# Item 2. Built Form\_Schofields Road Frontage

RFI1 to DPIE

Item 2. Built Form

ADDRESSING SCHOFIELDS ROAD AND THE PONDS

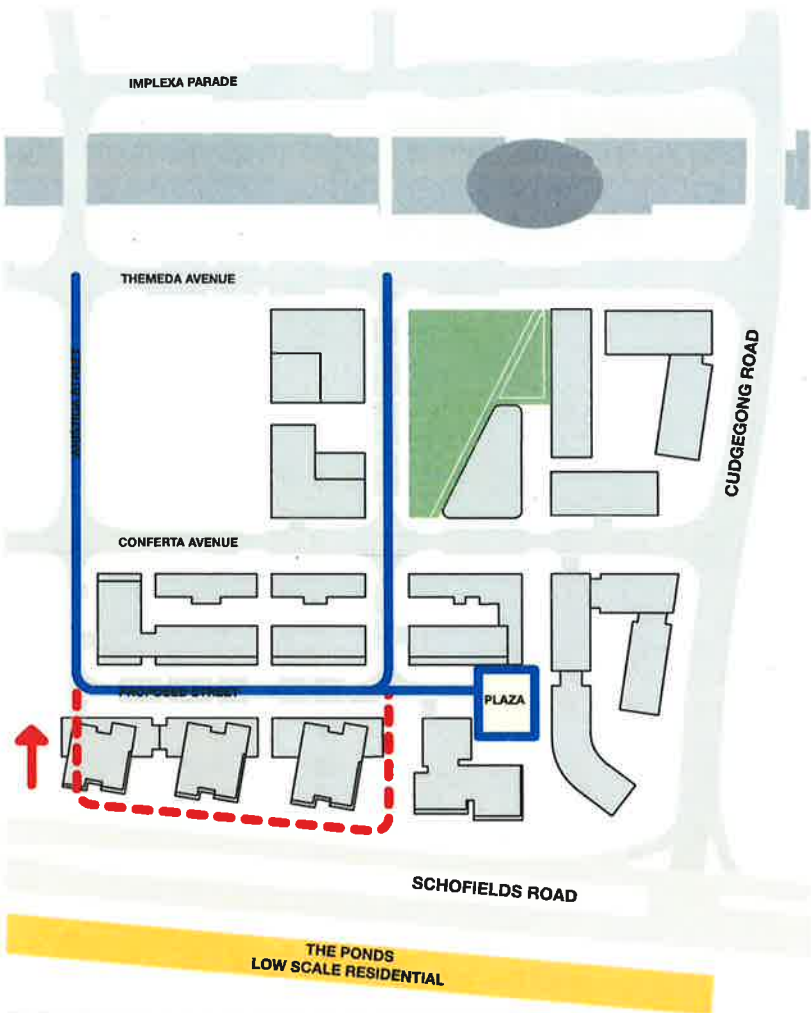
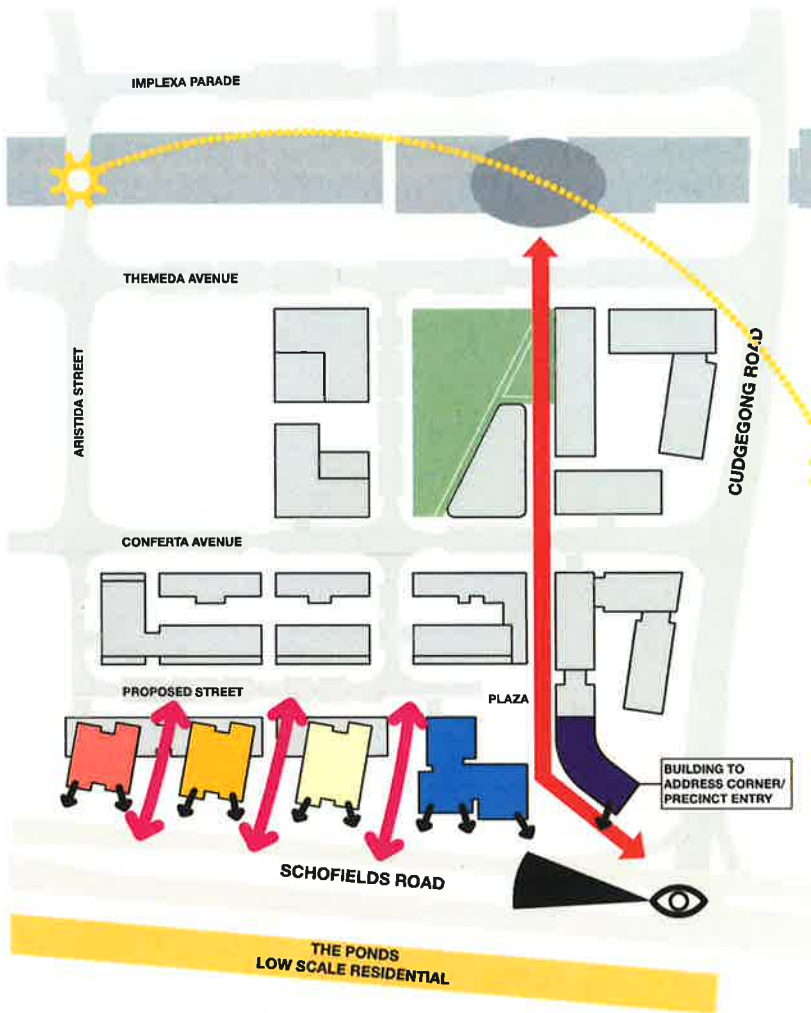
- i. Illustrate how the proposal complies with Condition B3 (a) and (b) of SSD 9063 which requires consideration of:
  - a. design the built form and landscape of the blocks fronting Schofields Road, including setbacks to the top-most floor, to address the urban qualities of Schofields Road and the adjacent low-density residential suburb of The Ponds

The following diagrams and 3D views describe the built form and landscape fronting Schofields Road and how they address the urban qualities of Schofields Road and the adjacent low-density residential suburb of The Ponds.

- ✓ Realign facade to orientate outlook north in response to solar access site building alignments
- ✓ Reduce upper building widths to the New Southern Road, increasing separation and outlook from the public domain
- ✓ Upper level setback to Schofields Road removed and balanced across new building form. Primary setback to Schofields Road maintained
